8755 NC. 42

COMMERCIAL
BUILDING REVIEW

KIDD'S PLACE SHELTER

RAFTER DETAIL
 KIDD'S PLACE SPORTING CLAYS
 NOT TO SCALE

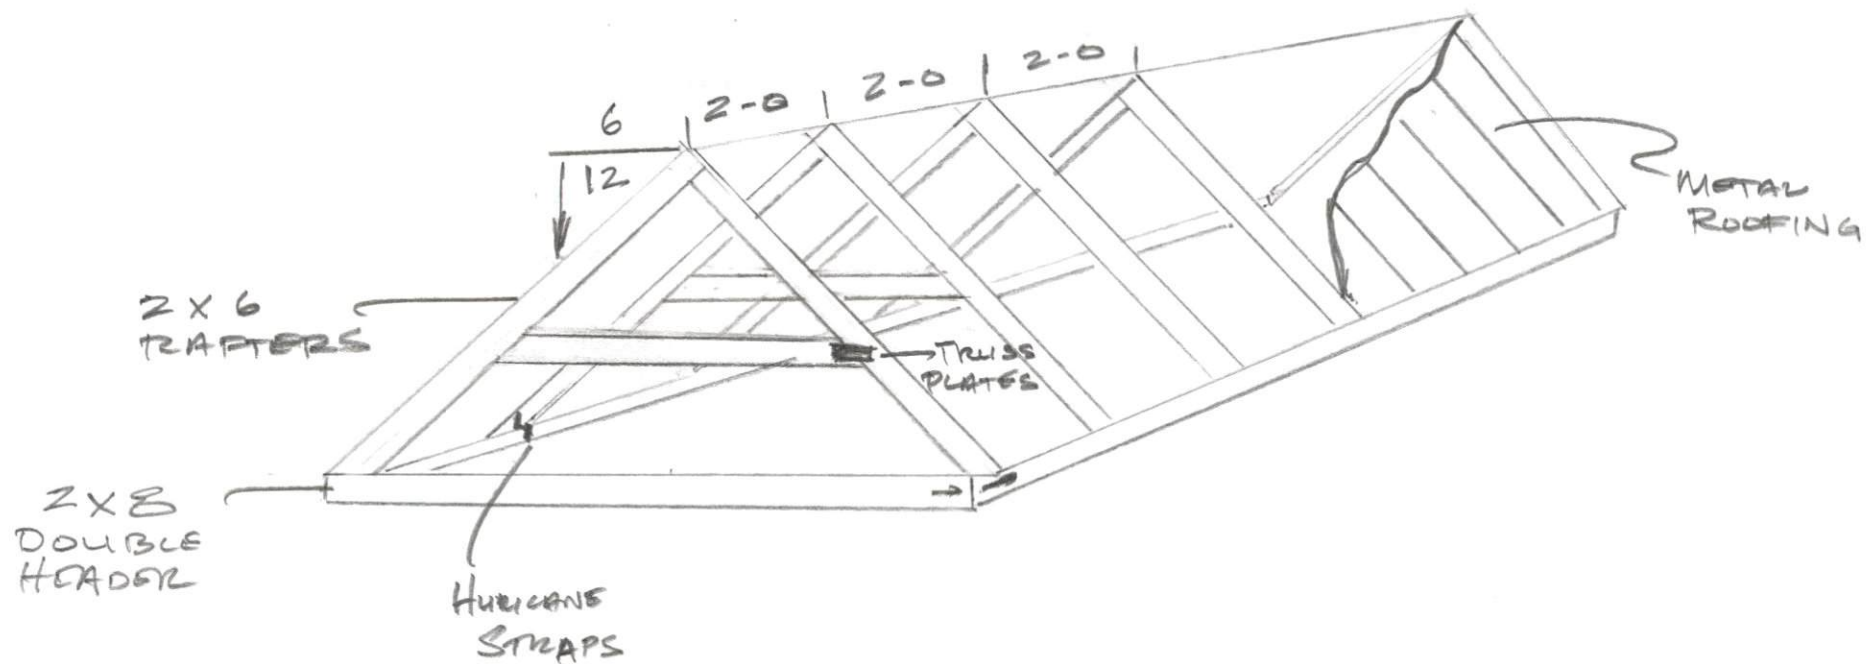
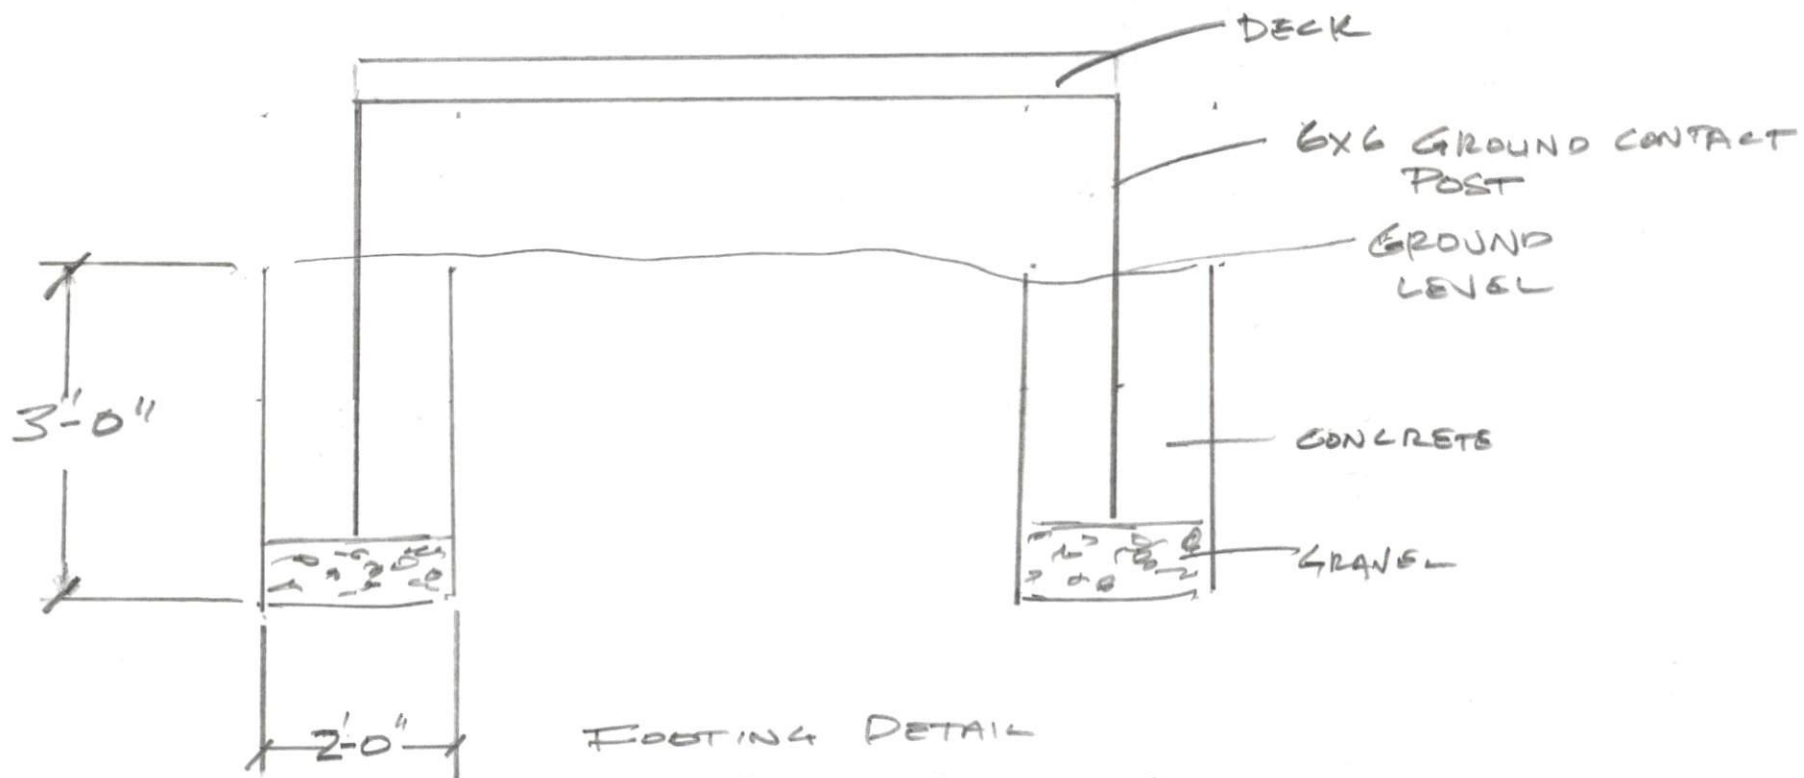
- ✓ 1. Need post spacing shown for deck and roof.
- ✓ 2. Need beam size shown for deck and roof.
- ✓ 3. Need floor joist size and spacing for deck and decking type
- ✓ 4. Roof must have ceiling joists in lower 1/3 of rafter span, or engineered trusses must be used. If using trusses, supply layout for truss supplier.
